January 6, 2016
Attn: Philip DiPierro
Development Review Coordinator

Responses to Review Comments for Single Family Site Plan

Murrell/Howe Duplex
Project ID 2015-02404
40 Quebec St.

1 Site Plan
3/16" = 1'-0"

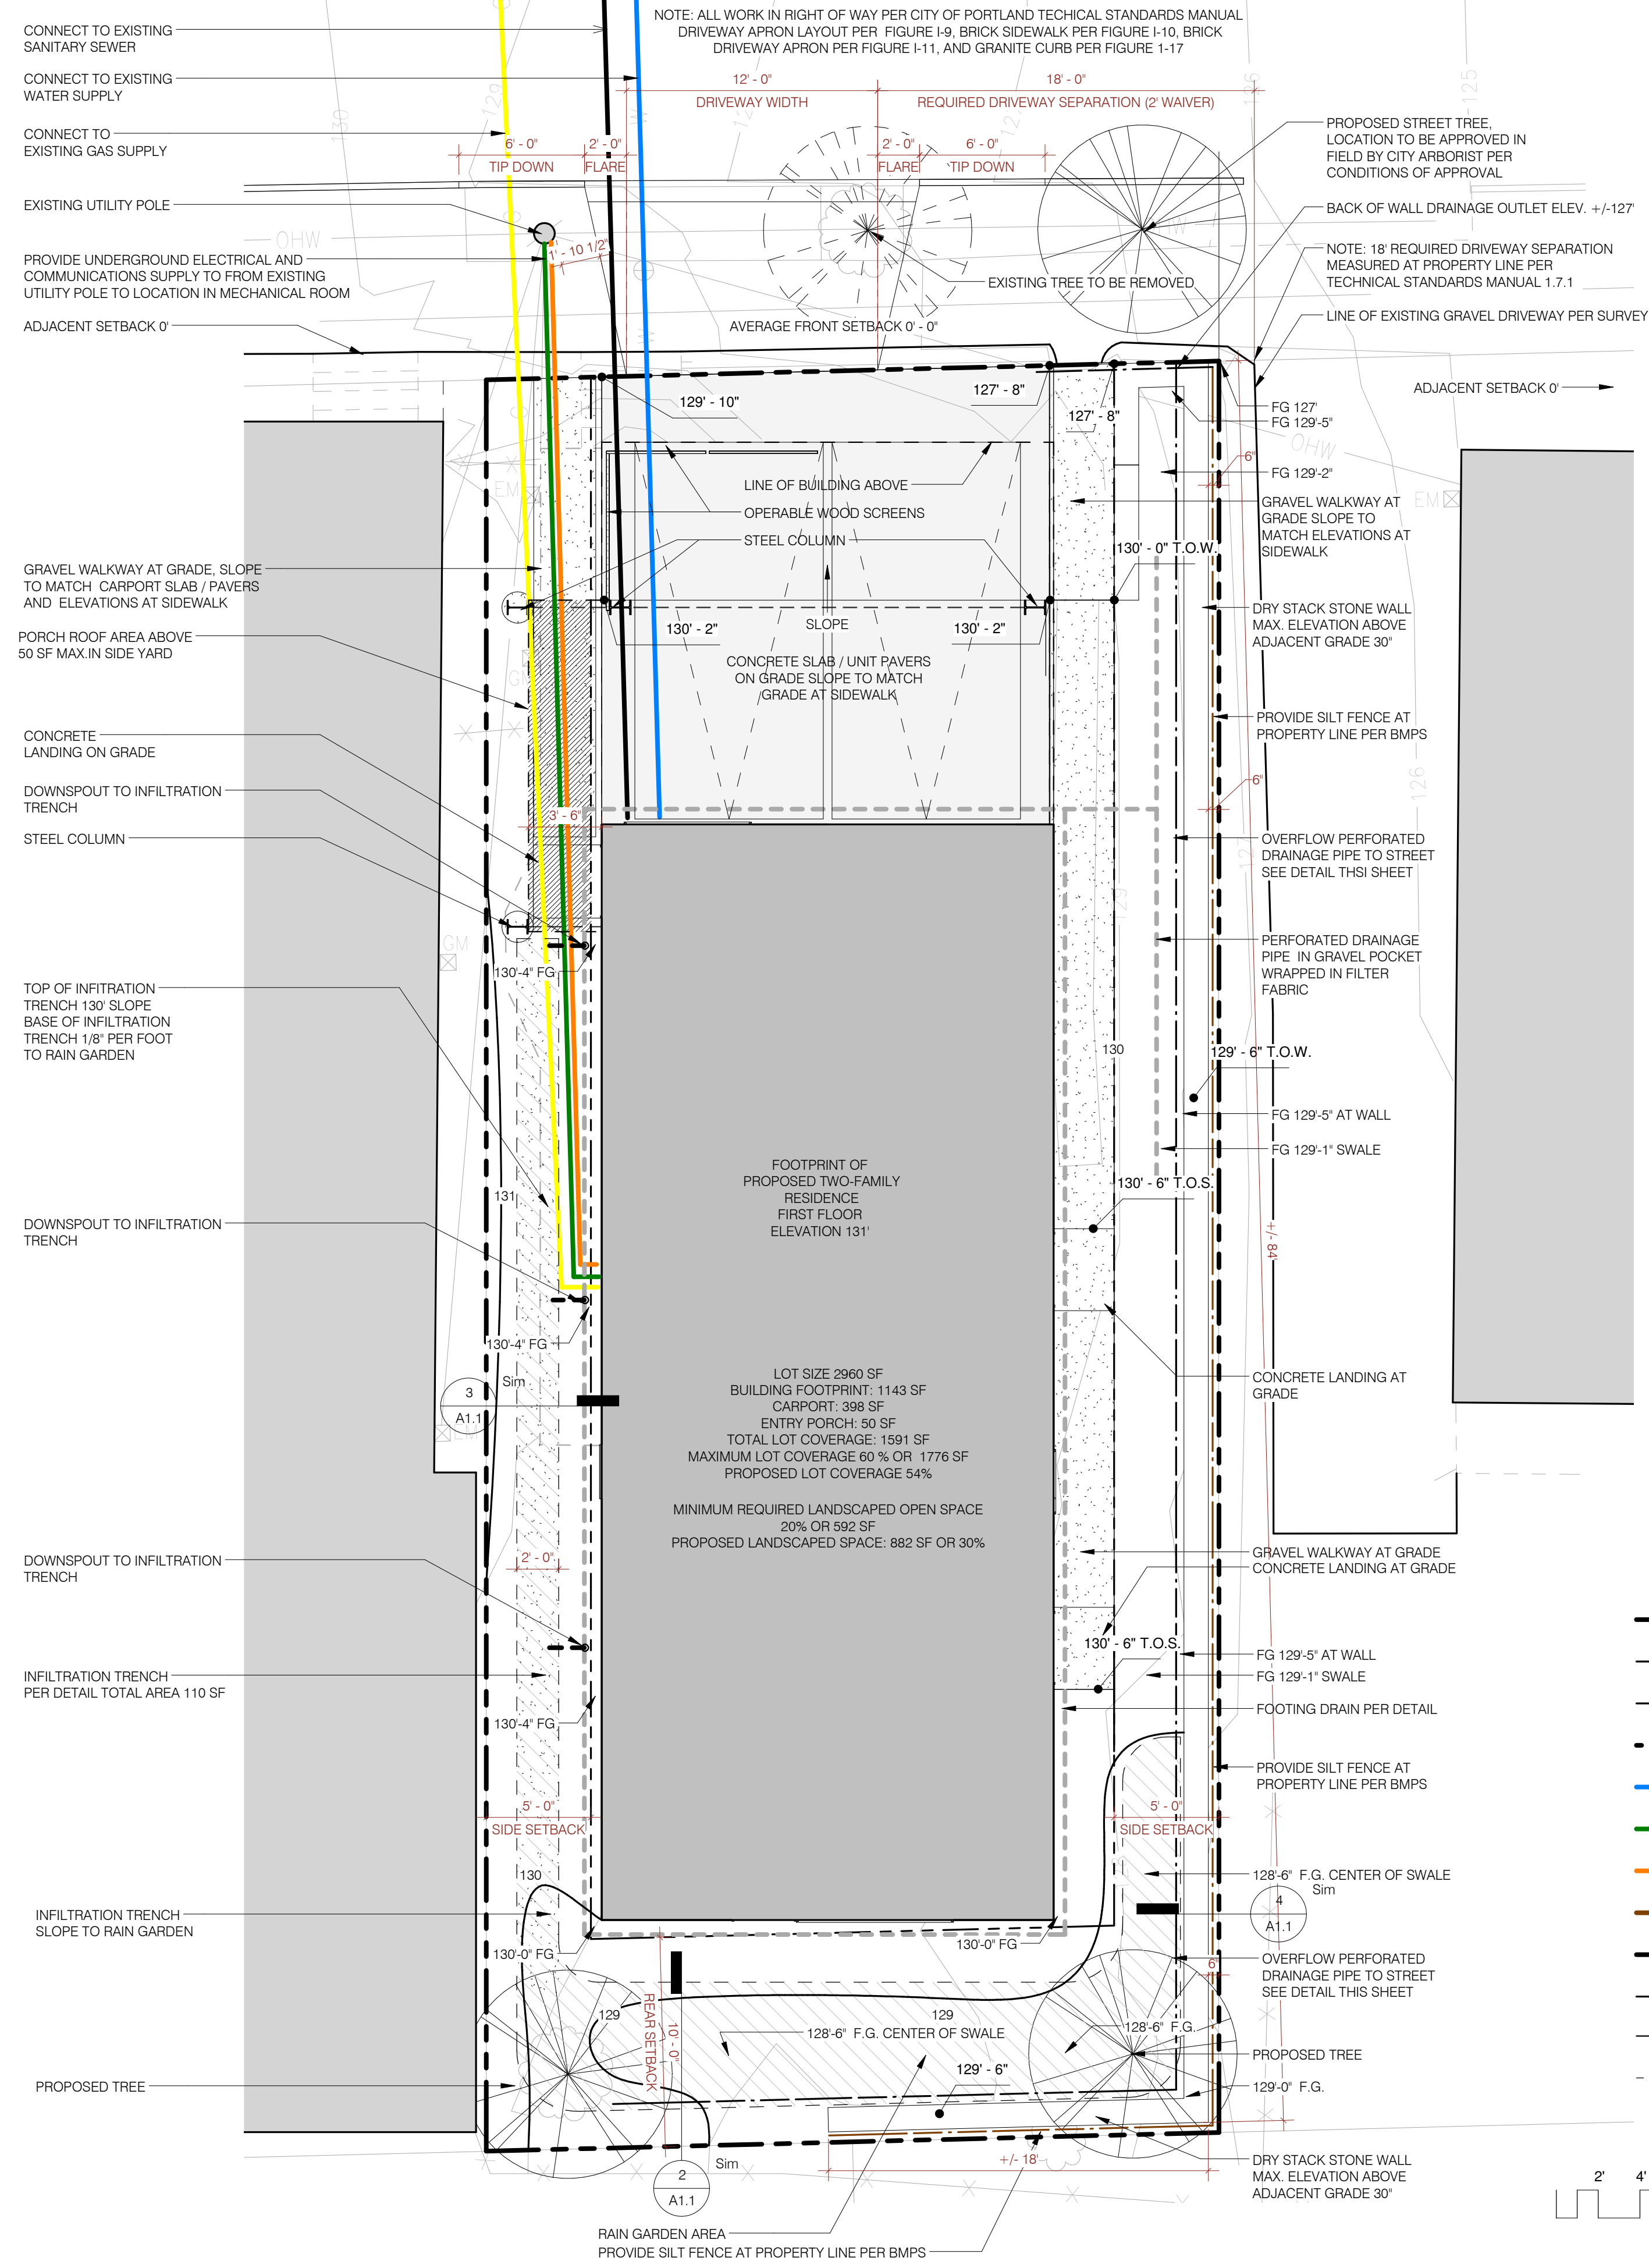
Site Plan Requirements

1. Standard size (18'X9') parking spaces are indicated on the site plan.
2. Zoning District (R-6) has been added to the Site Notes on sheet A 1.1.
3. The soil type (HIB) has been added to the Site Notes on sheet A1.1.

4. A Construction Management narrative has need added to the Site Notes on sheet A1.1. The location of proposed silt fencing has been indicated on the Site Plan.

5. The revised Site Plan includes the following measures to ensure the adjacent properties will not be negatively impacted by storm water surface drainage:

- Walkways along the side yards have been changed from hardscape to gravel increasing infiltration area for storm water.
 - An infiltration trench has been added along the western edge of the structure to capture roof runoff from downspouts. This infiltration trench feeds into a rain garden

- A rain garden has been located at the rear and east side of the property. The infiltration trench and rain garden have been sized according to the guidelines provided by the Maine DEP that indicate rain gardens are most effective when sized to 20-30% of the drainage area. The roof area of the home is 1575 SF. The proposed infiltration area of the infiltration trench and rain garden is 394 SF – equal to 25% of the drainage area.

- The soil type (HIB – hydrologic soil group A) has a natural drainage class that is very well drained with very low runoff.
 - Spot Elevations have been added along the swale behind the dry stack stone wall at the eastern edge of the property.

6. There is only room for 1 street tree. In substitution for the second required street tree, a contribution will be made to the tree fund. A note has been added to the Site Notes on sheet A1.1.

7. Section details of the infiltration trench and rain garden have been added to the Site Plan, A1.1.
8. The owners are requesting a Waiver from the required 20' minimum separation between driveways. The request for this waiver is being made as a separate submittal. The proposed driveway width has been revised to comply with the maximum driveway width of 20'.
